Marine  
Management  
Organisation

MMO Reference: DCO/2019/00005  
Planning Inspectorate Reference: EN010117  
Identification Number: 20045232

**Planning Act 2008, E.On Climate and Renewables UK Ltd, Proposed Rampion 2 Offshore Wind Farm Order**

**Deadline 2 Submission**

| Figure number | Figure Title | APFP number | Ecodoc number | Revision | Revision Date |
|---------------|--|-------------|---------------|----------|---------------|
| Figure 8.9 | Potential sandeel habitat sediment classifications within the Rampion 2 fish | 5 (2) (a) | 004866100-01 | B | 28/02/2024 |

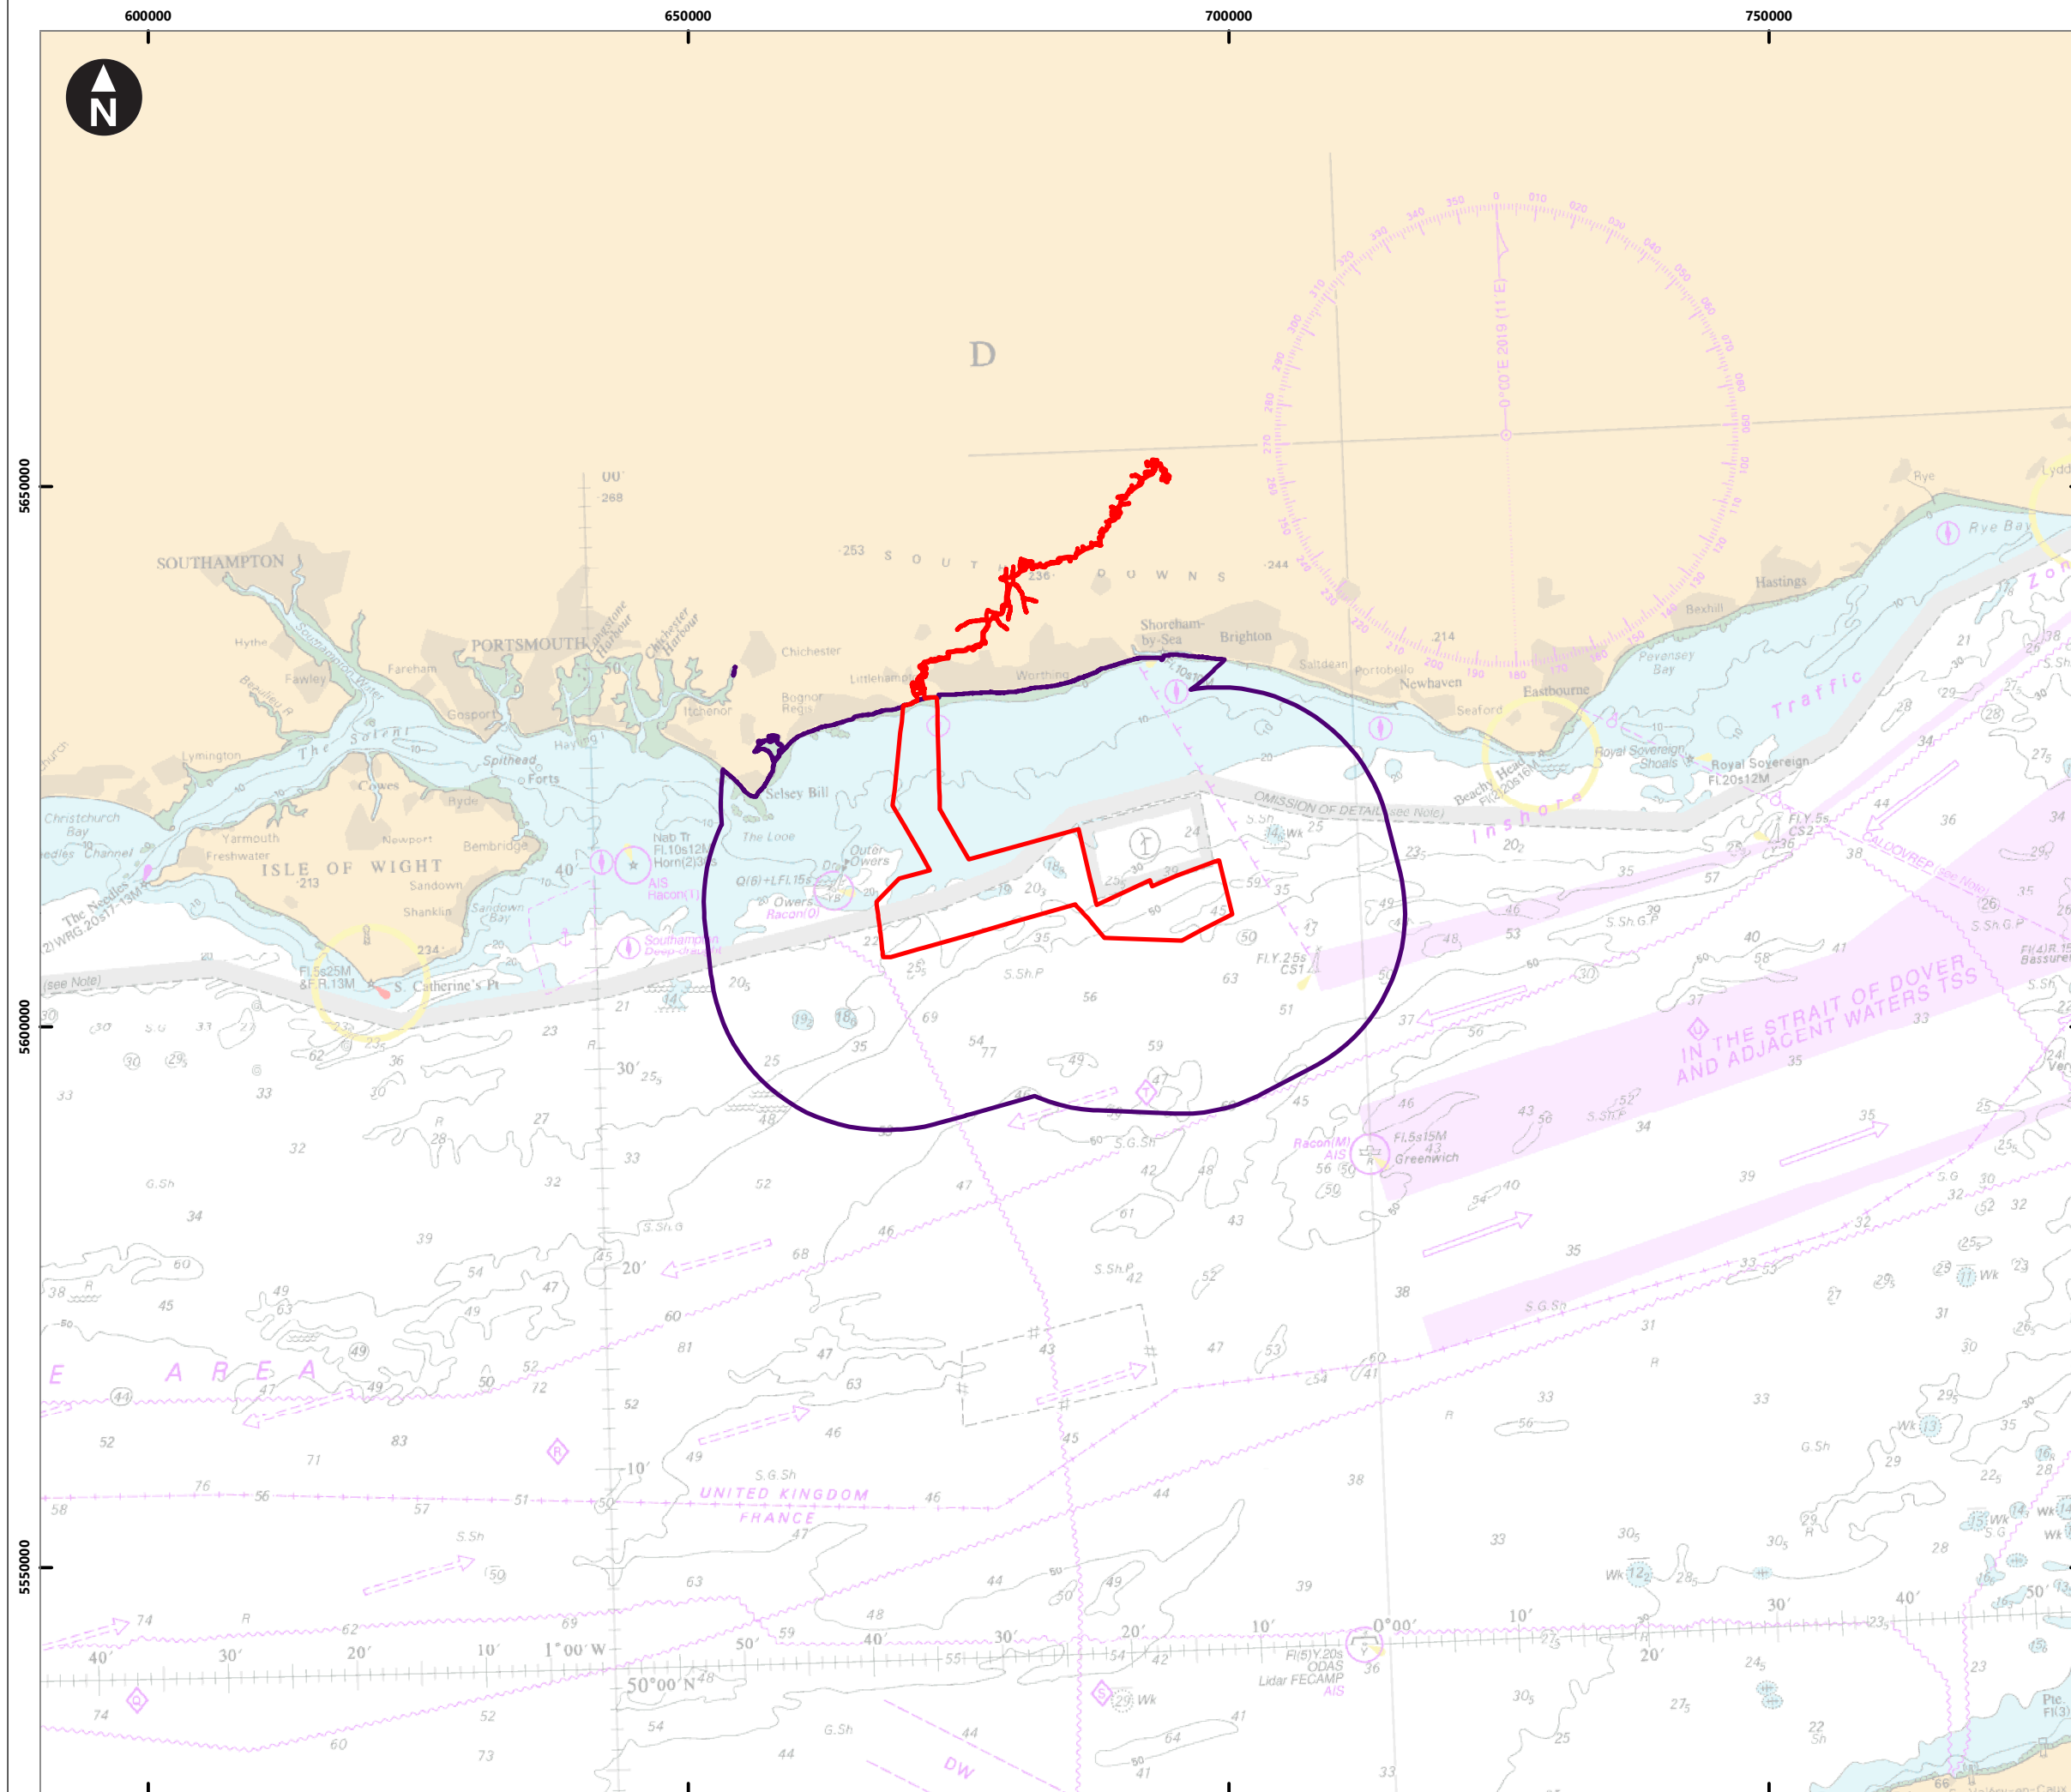
- 1.12.2 MMO 4.6.15: The MMO thanks the Applicant for acknowledging the inconsistencies in Figures 8.9 and 8.10 of Chapter 8: Fish and Shellfish – Figures, Volume 3 (APP-081), and for providing revised figures as recommended by the MMO in Chapter 8: Fish and Shellfish, Volume 3 of the ES – Figures (REP1-007), submitted at Deadline 1.
